TfNSW Reference: SYD15/01390/27
Departments Reference: SSD 7348 MOD 5

**SECTION 4.55 (1A) MODIFICATION TO APPROVED OAKDALE WEST ESTATE -
WAREHOUSE & DISTRIBUTION FACILITY - ERSKINE PARK**

Figure 4 | Proposed Concept Proposal

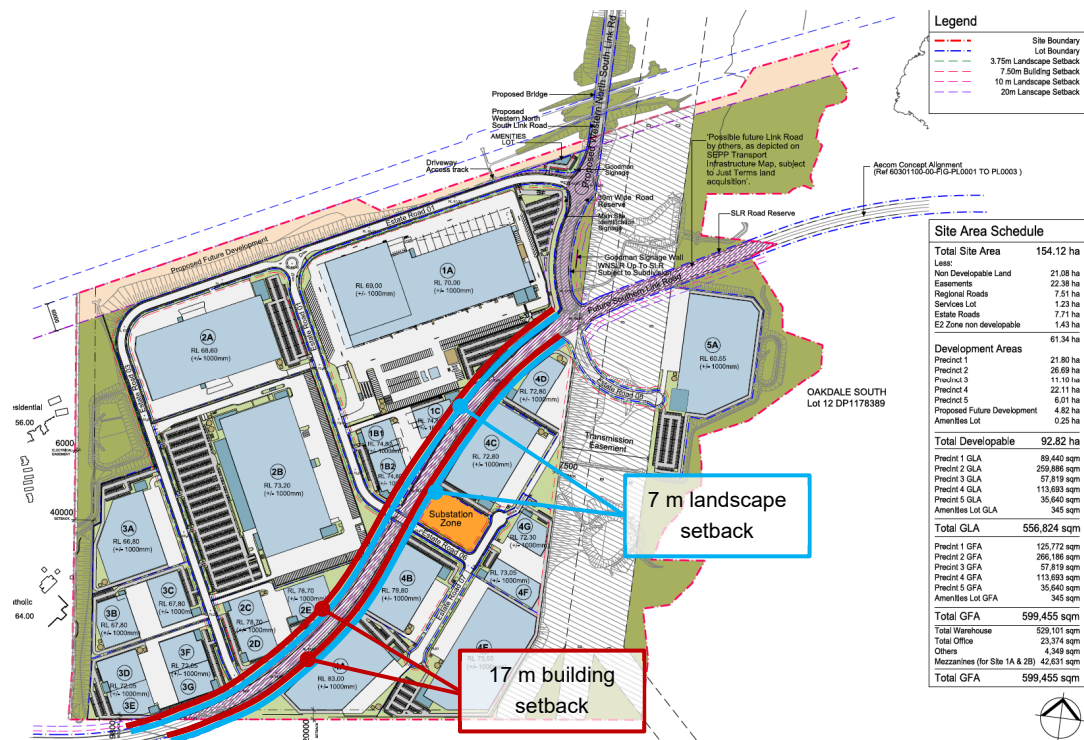
TfNSW has reviewed the submitted documentation and as stated in our previous correspondence raises no objection to reduce the setback from 20 m to 17 m.

However, land required for Southern Link Road (SLR) does not align with the land identified in the proposed subdivision plan. The land requirement for the SLR would be a combination of purple and red line boundaries shown on the attached plan. The proposed subdivision is generally along the purple line boundary.

Transport for NSW (TfNSW) would raise no objection to the proposed subdivision (along the purple boundary) provided that there are no structures or buildings (including utilities) within the land identified by the purple line and red line.
